**ADC Planning Consultation
Response from the Historic Buildings Adviser**

Application Number	FG/120/12
Address	The Old Barn, Ferring
Description	Amendments to approval FG/6/12/ for COU. Addition of car shelter.
Case Officer	Anita Gardner
Site Visit

Car Parking Shelter - Plan & Elevations

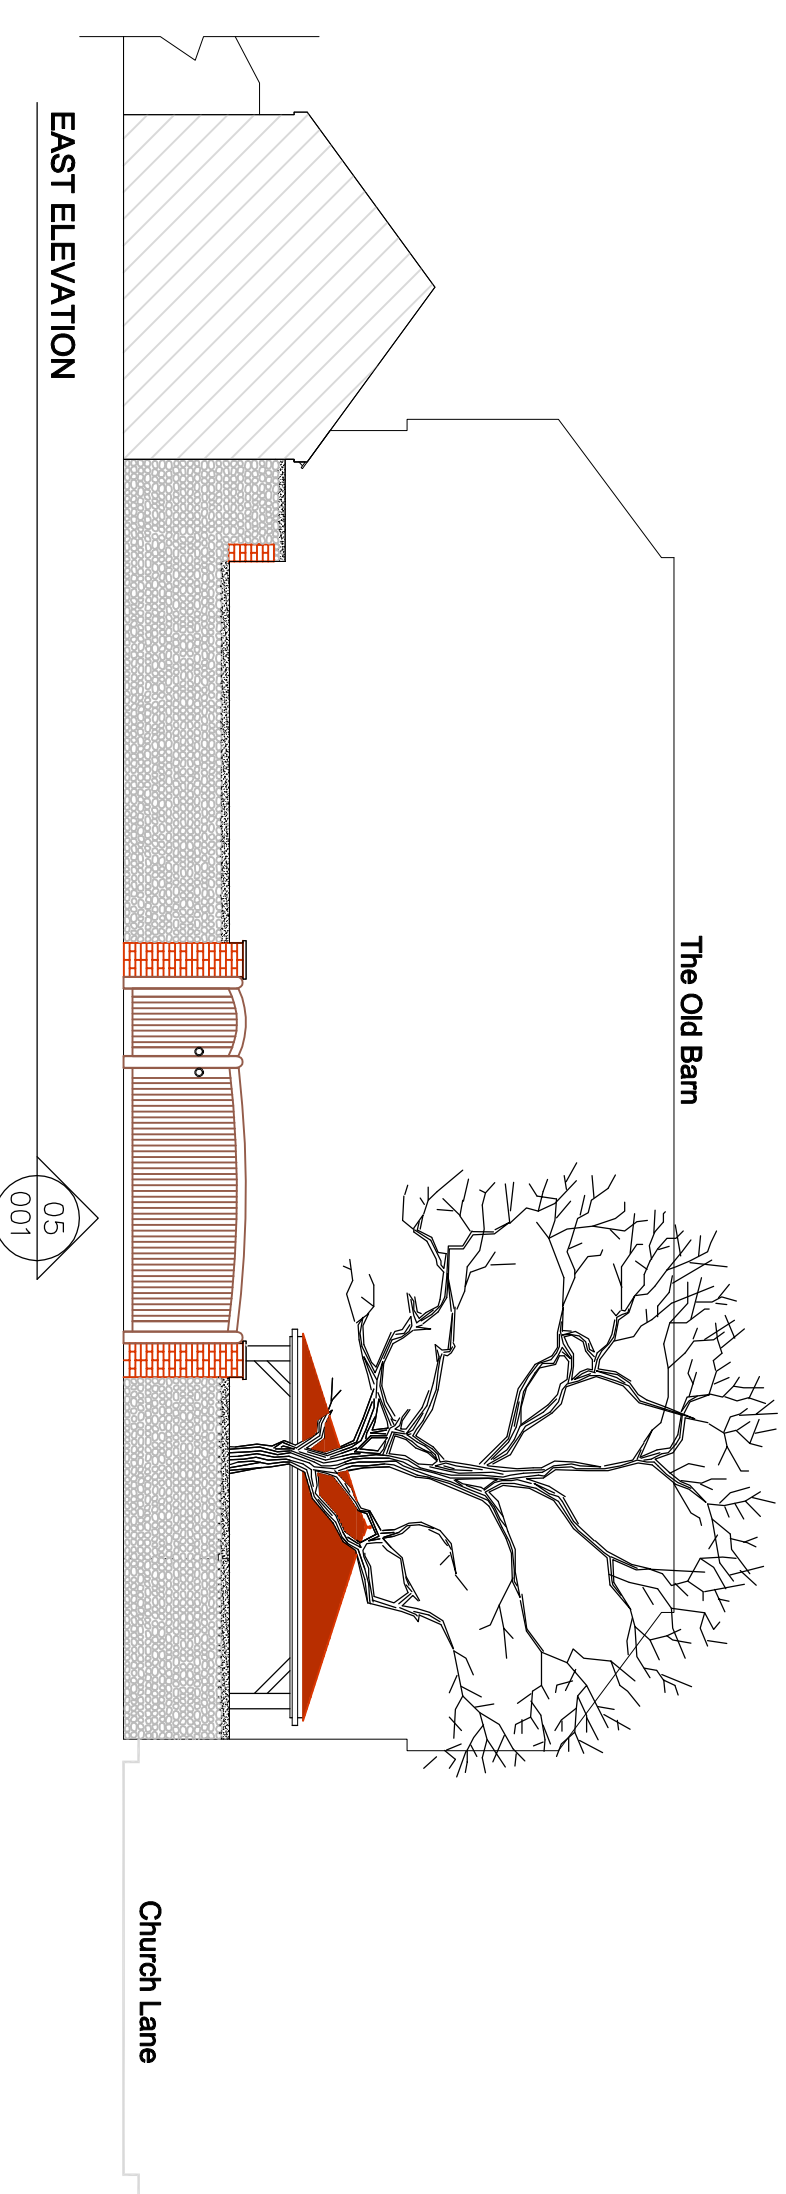
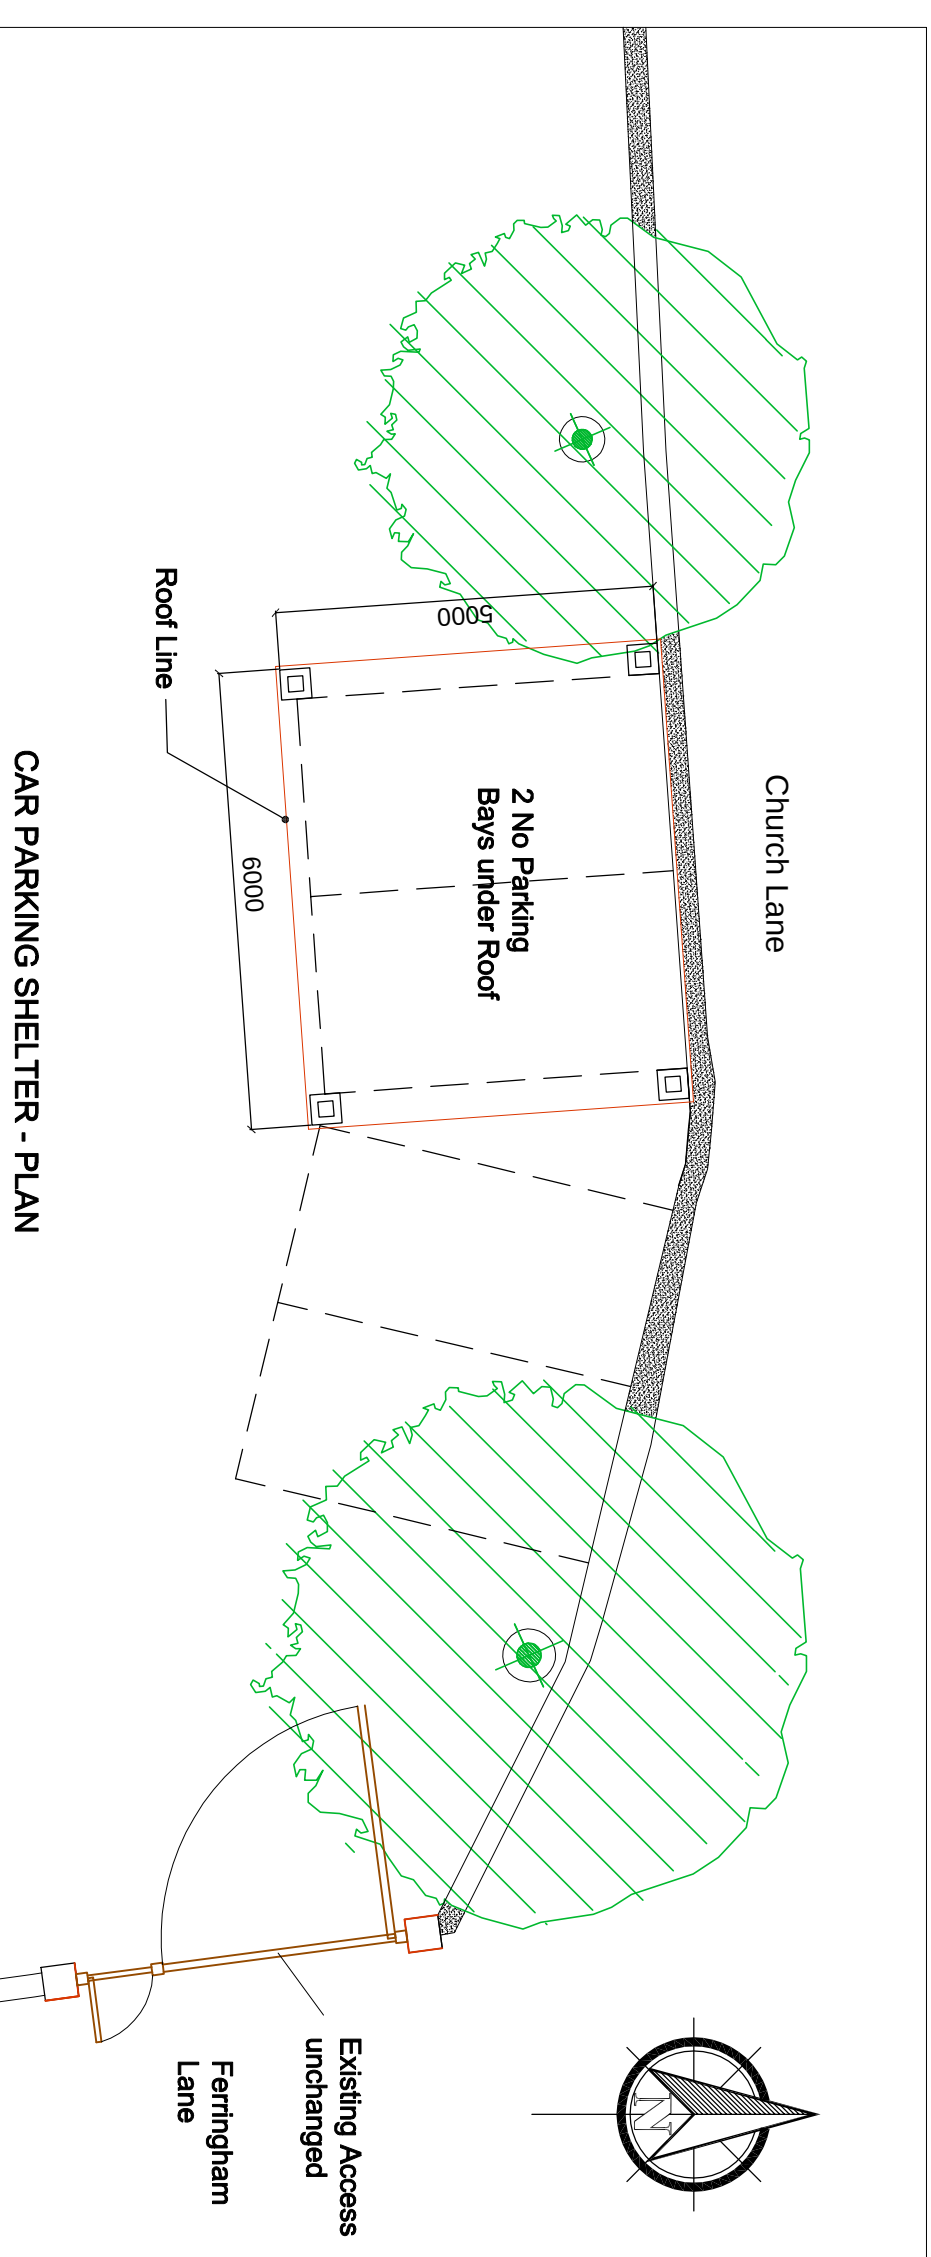
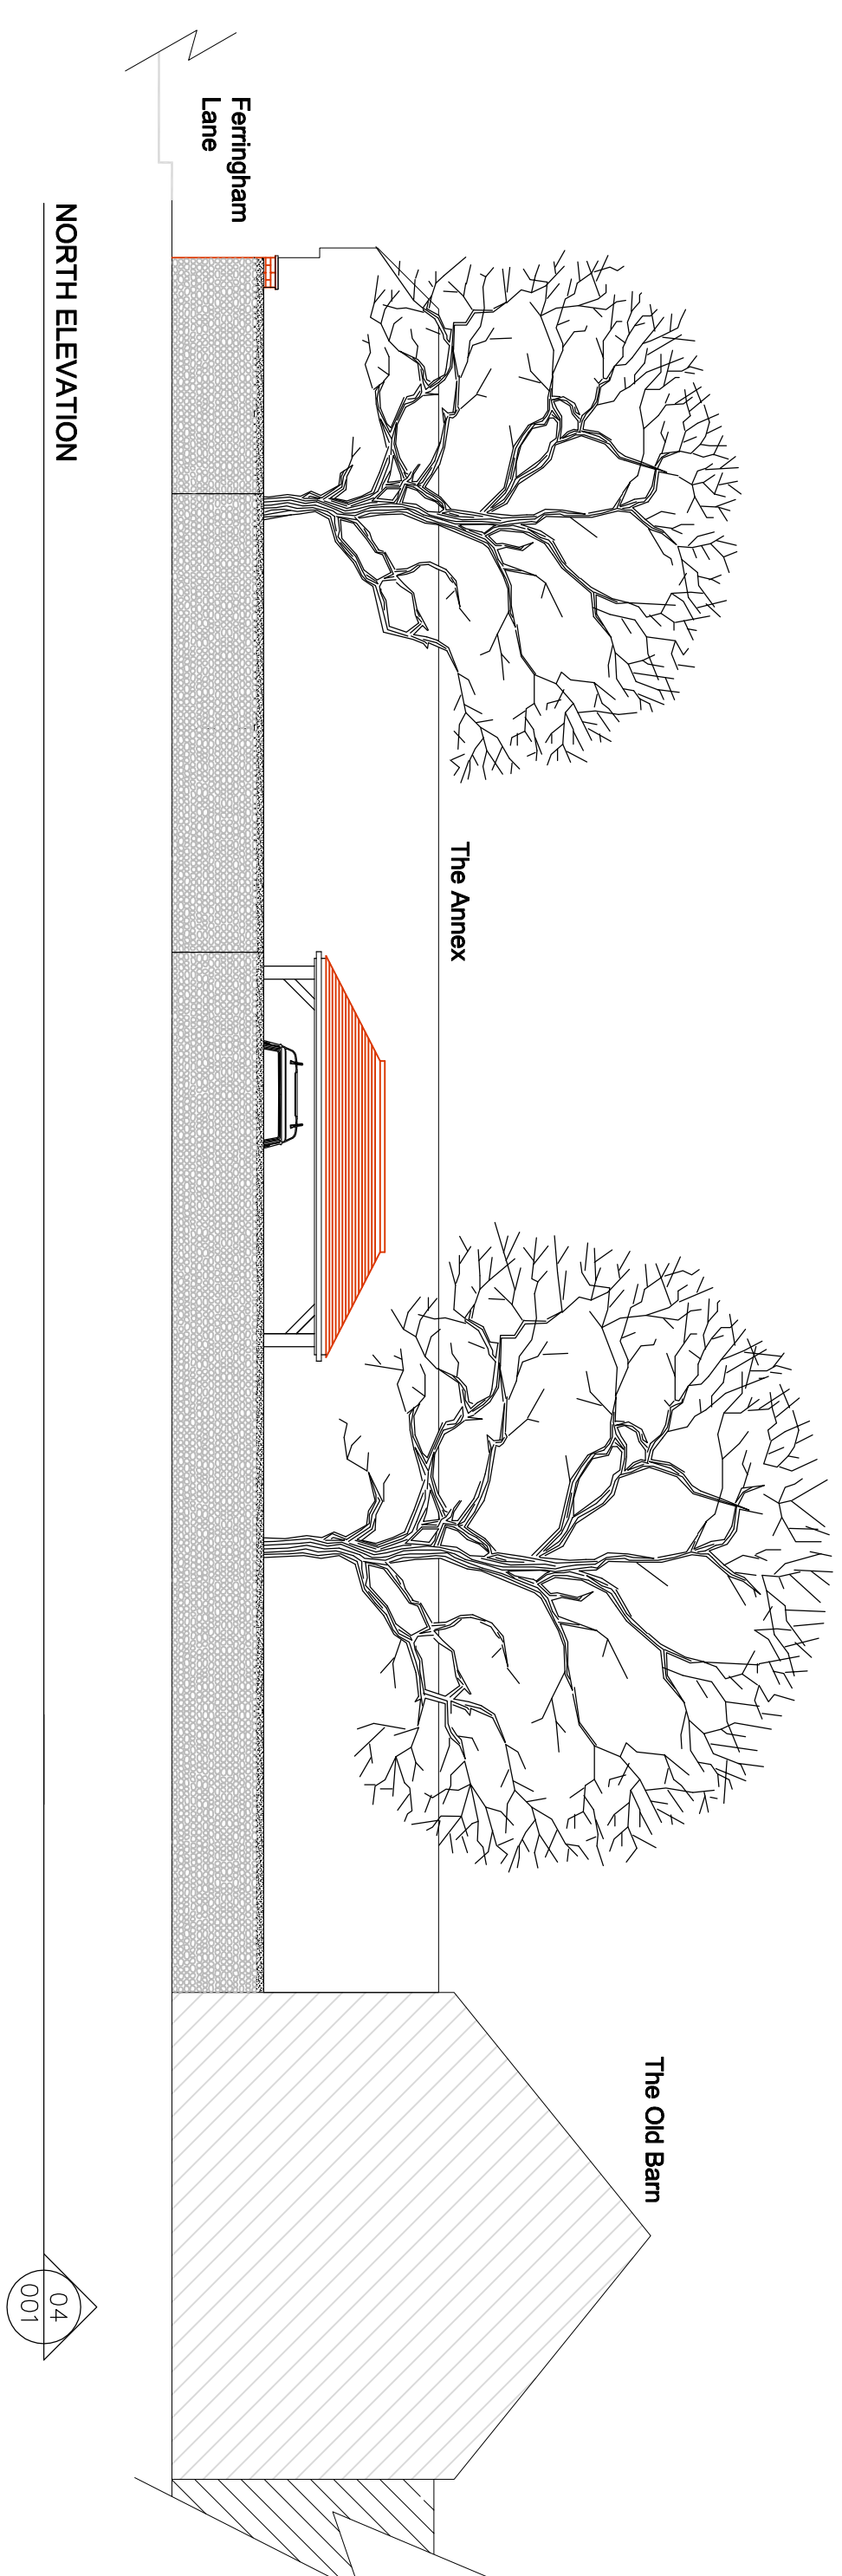
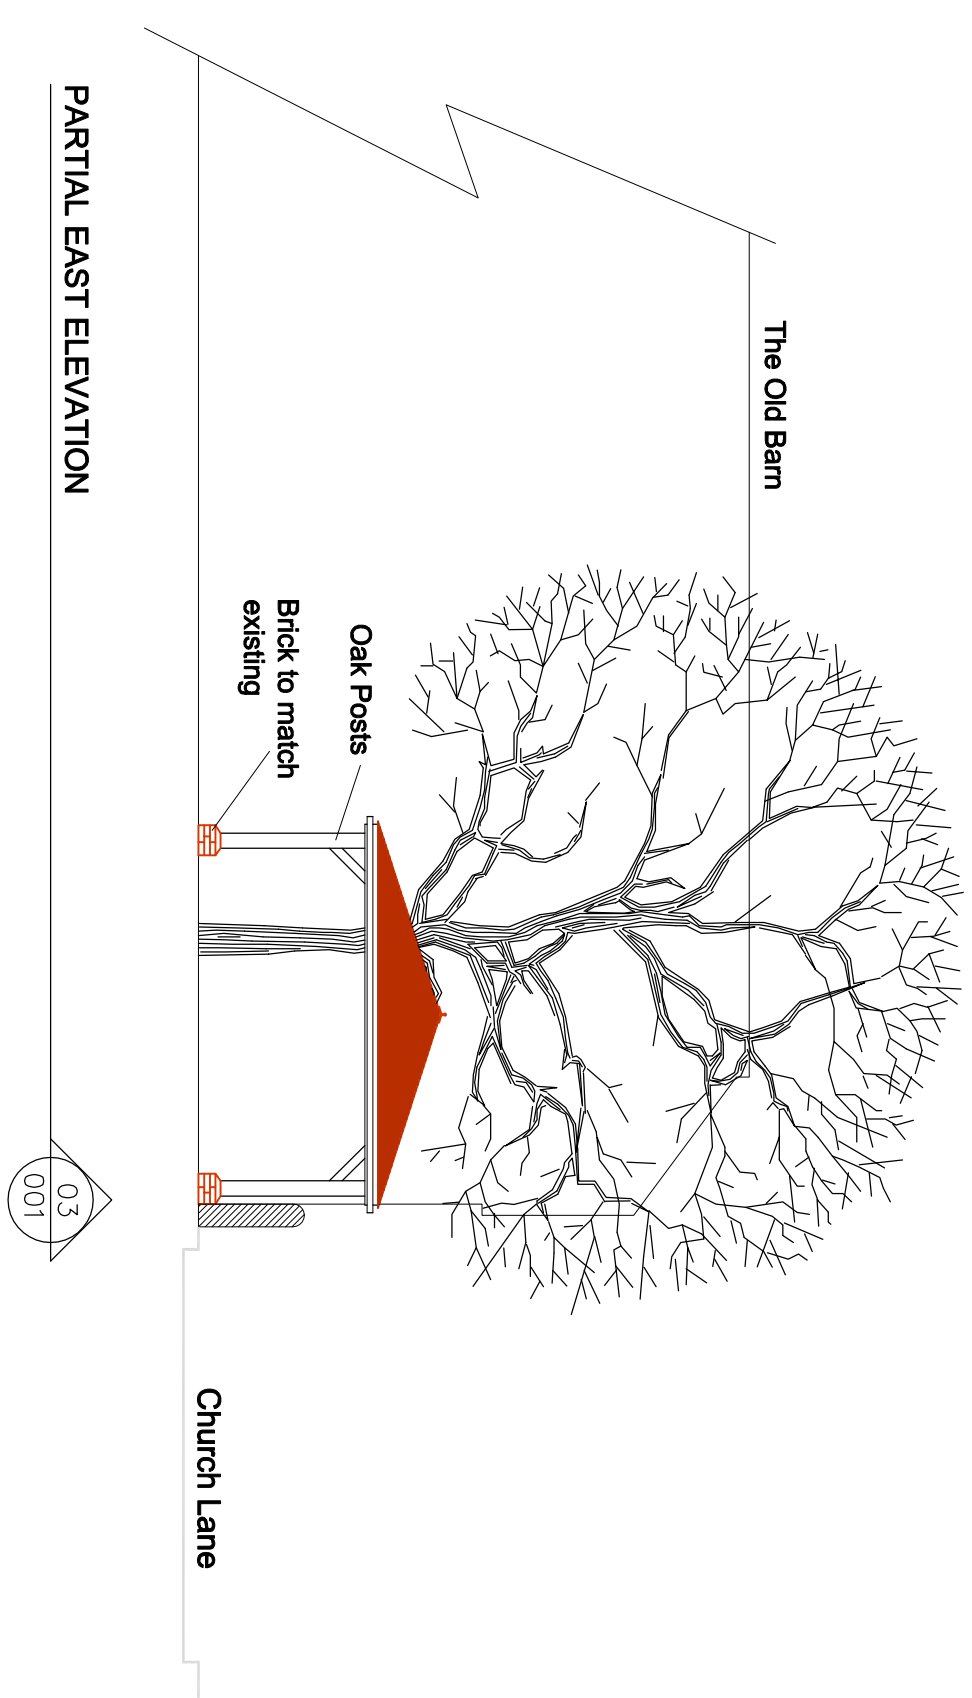
The 'cart shed' design proposed here, by comparison, is fully open and not particularly convincing in this context. It is also quite different in design from the historic examples provided which have steeper roof slopes more appropriate for clay tiles. As such, it is not appropriately 'agricultural' in character and in turn could detrimentally affect the setting of the historic building group, their appreciation and amenity.

That said, I would suggest that any type of shelter is resisted here on the basis that it would affect the setting of the historic building group.
